**Re: PA23-015 – MSR Tuscany Woods Townhomes – Technical Review 2**

To: Amy Hess, Senior Planner  
From: Brian Merkley, Deputy Fire Marshal  
Date: October 26, 2023  
Subject: PA23-015 4407 84th St. Tuscany Woods Townhomes

RE: MSR Tuscany Woods Townhomes, File# PA23-015  
Proposed 37-unit townhome development, utilizing Residential Density Incentives to achieve 11 bonus units, and associated improvements. Access proposed from 84<sup>th</sup> Street NE.  
4407 84<sup>th</sup> Street NE & Parcel #30052100105200

MSR TUSCANY WOODS
DWG FILENAME: 221215-PRELIM.DWG DESIGNED BY: JTK DATE: 05-10-2023 SCALE: 1"=40' JOB NO.: 22-1215 SHEET: S1

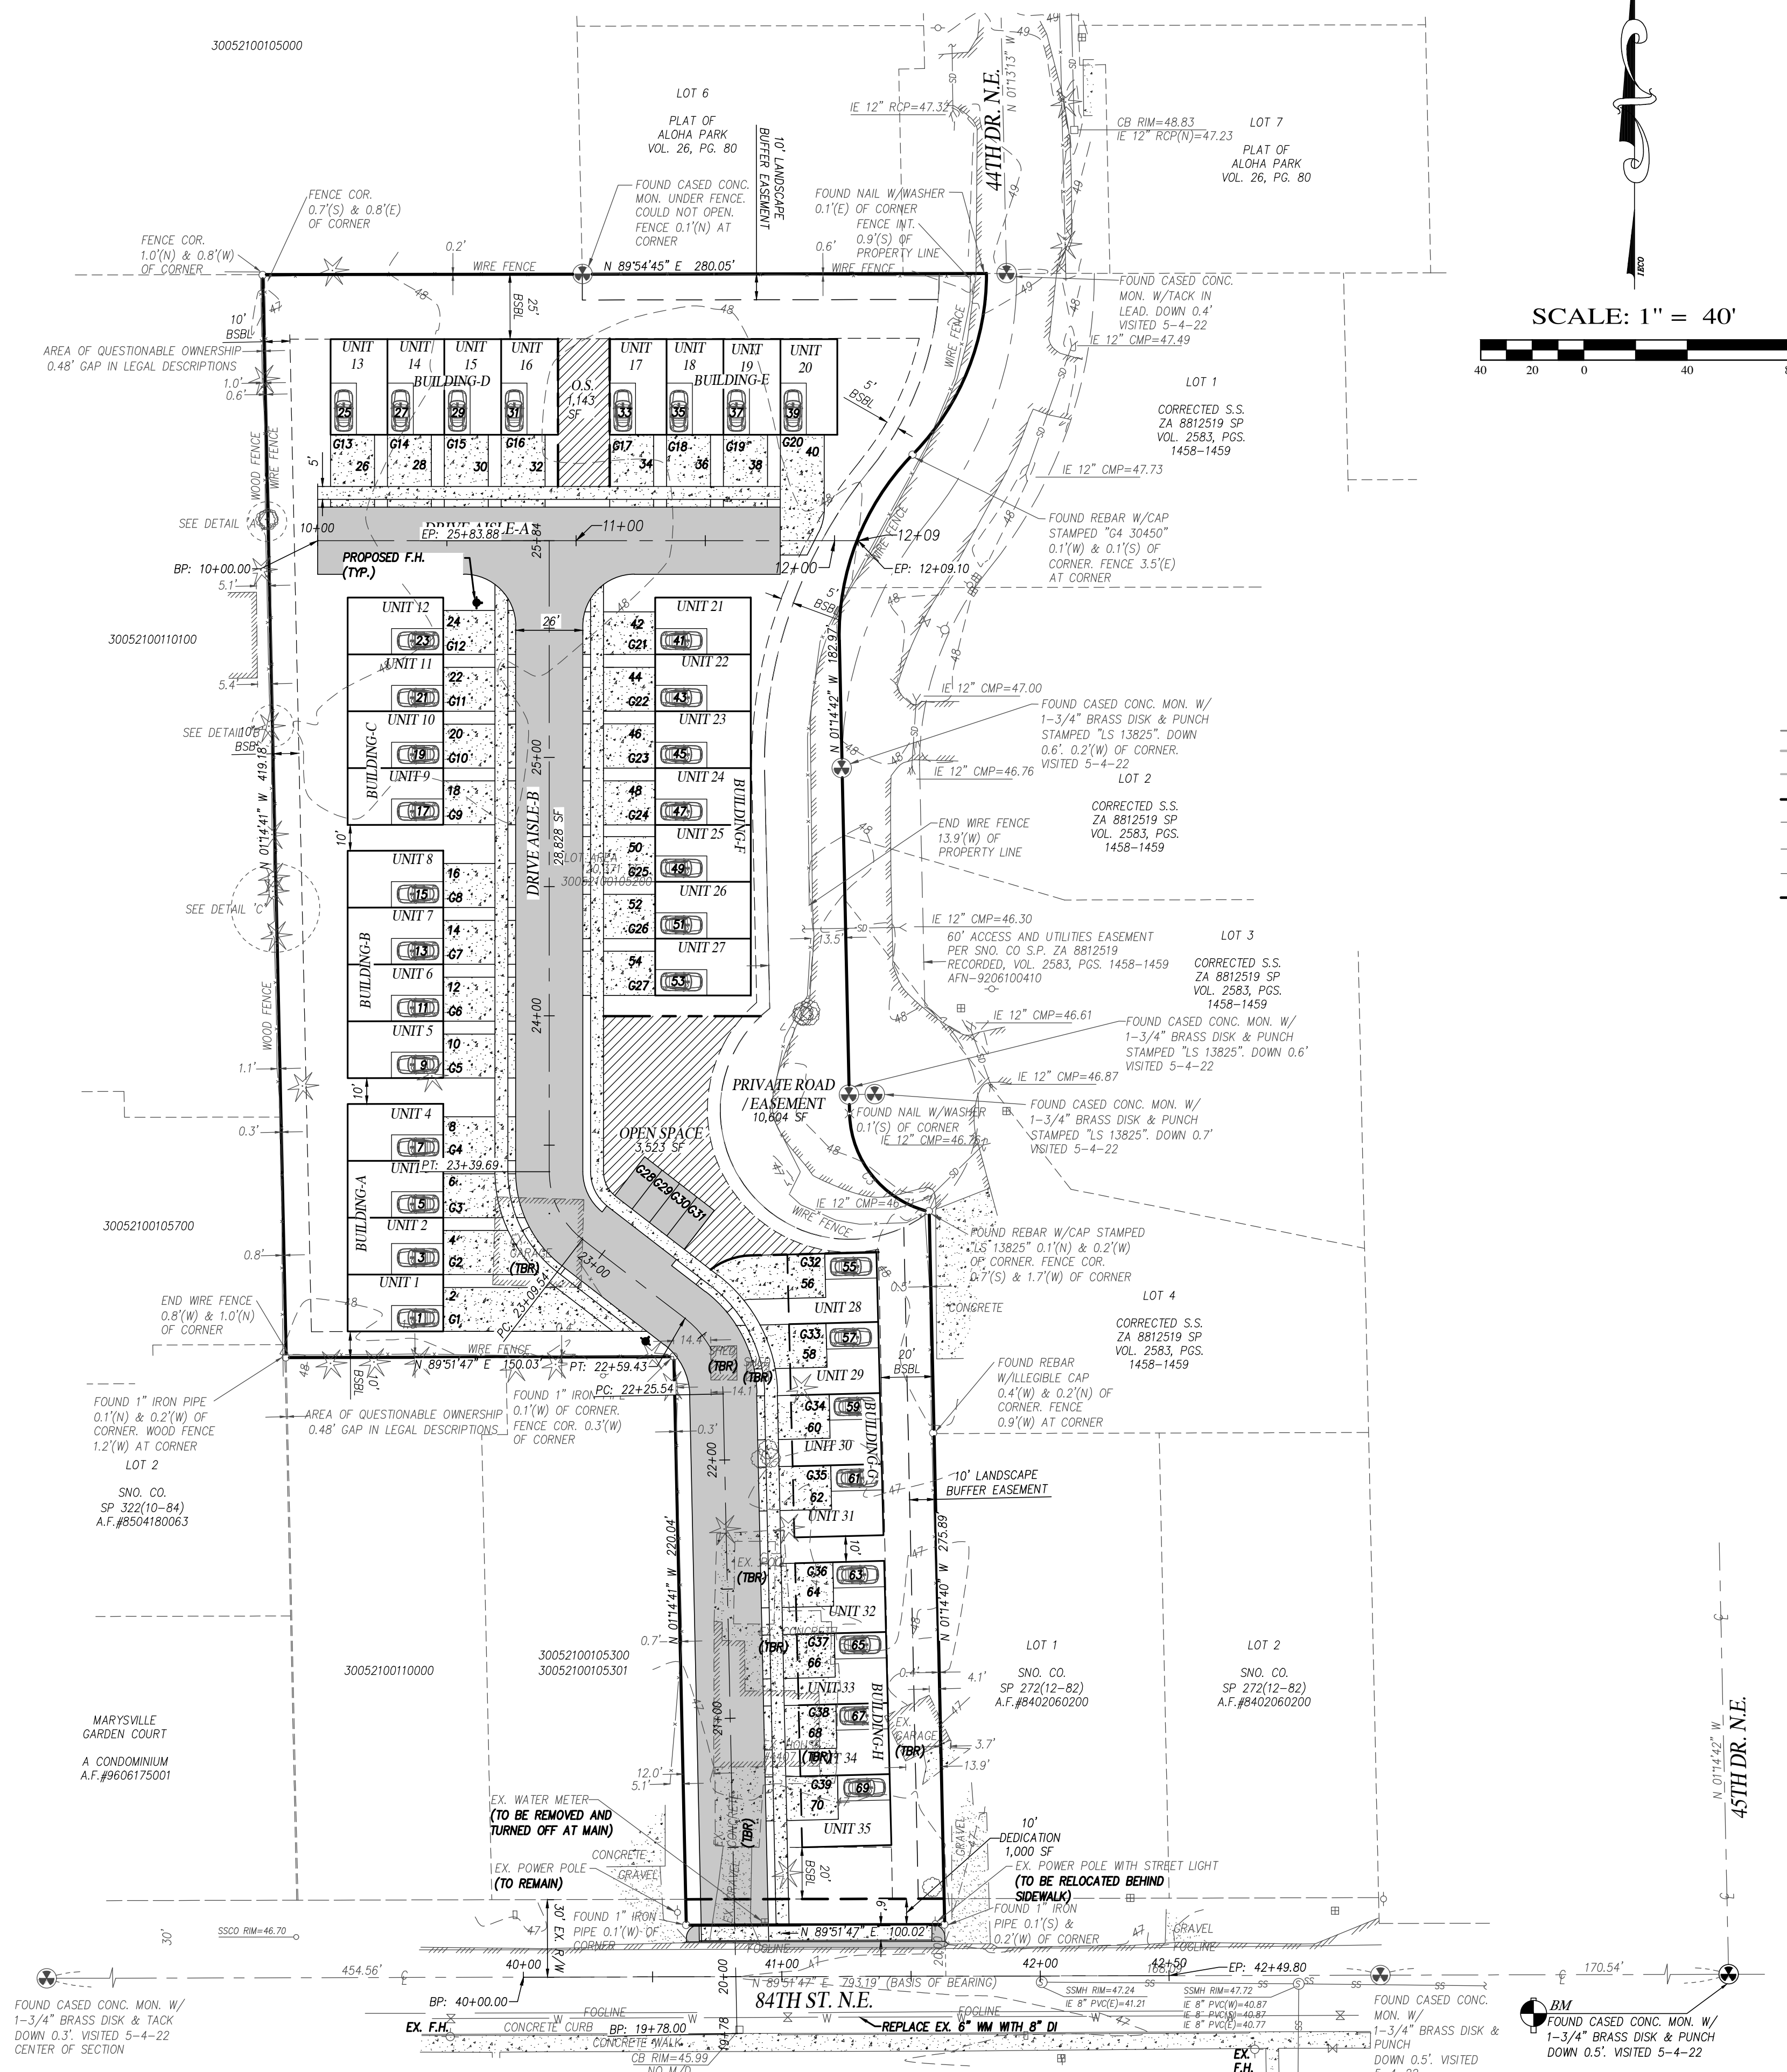
1. What is proposed for the portion of the private road (44<sup>th</sup> Drive NE) that is on the project property? Prior to further review, please identify how this area will be addressed. Is a Boundary Line Adjustment proposed? Whatever is proposed will likely impact allowable density, setbacks, etc.

3. Setbacks for the proposal are as follows:
  - . Front (south) - 20 feet
  - . Rear (north) - 25 feet
  - . Side (west) - 10 feet
  - . Side (east) - 20 feet

4. A 10-foot L1 buffer is required along the entire eastern project boundary (MMC 22C.010.090(10)). A six foot sight obscuring fence is required along this boundary as well.

5. Building setbacks shall be measured from the property lines, not the edge of the private road as it appears has occurred.
6. In order to meet parking standards, driveways shall be a minimum of 20 feet in depth. A number of the unit driveways do not appear to meet this requirement. Please review and revise accordingly.

7. All garages proposed to be used to meet unit parking requirements shall be a minimum of 20 feet in depth. Please demonstrate that no equipment is proposed to be placed

- The sidewalks on the south portion of Drive Aisle A effectively lead to nowhere and should be removed (see areas highlighted below).

- There is a portion of pavement that appears to be the proposed access for unit 20 that is shown in the private road (see area highlighted below). This is not acceptable and will need to be revised. No access from 44<sup>th</sup> Drive is permitted.

Required setbacks and landscaping shall not be counted towards the common open space. Please provide a plan demonstrating compliance with and identifying common and private open space. The area behind units 28-35 that is required landscape buffer cannot be counted towards the unit's private open space.

11. Planter strips between units shall be a minimum of 5 feet in width.
12. While technically not required, the 10' L1 Buffer along the portion of the northern property boundary adjacent to the single family zone could be extended to run the entire length of the northern project property line to create a cohesive, finished asset to the future residents and community, rather than ending abruptly.
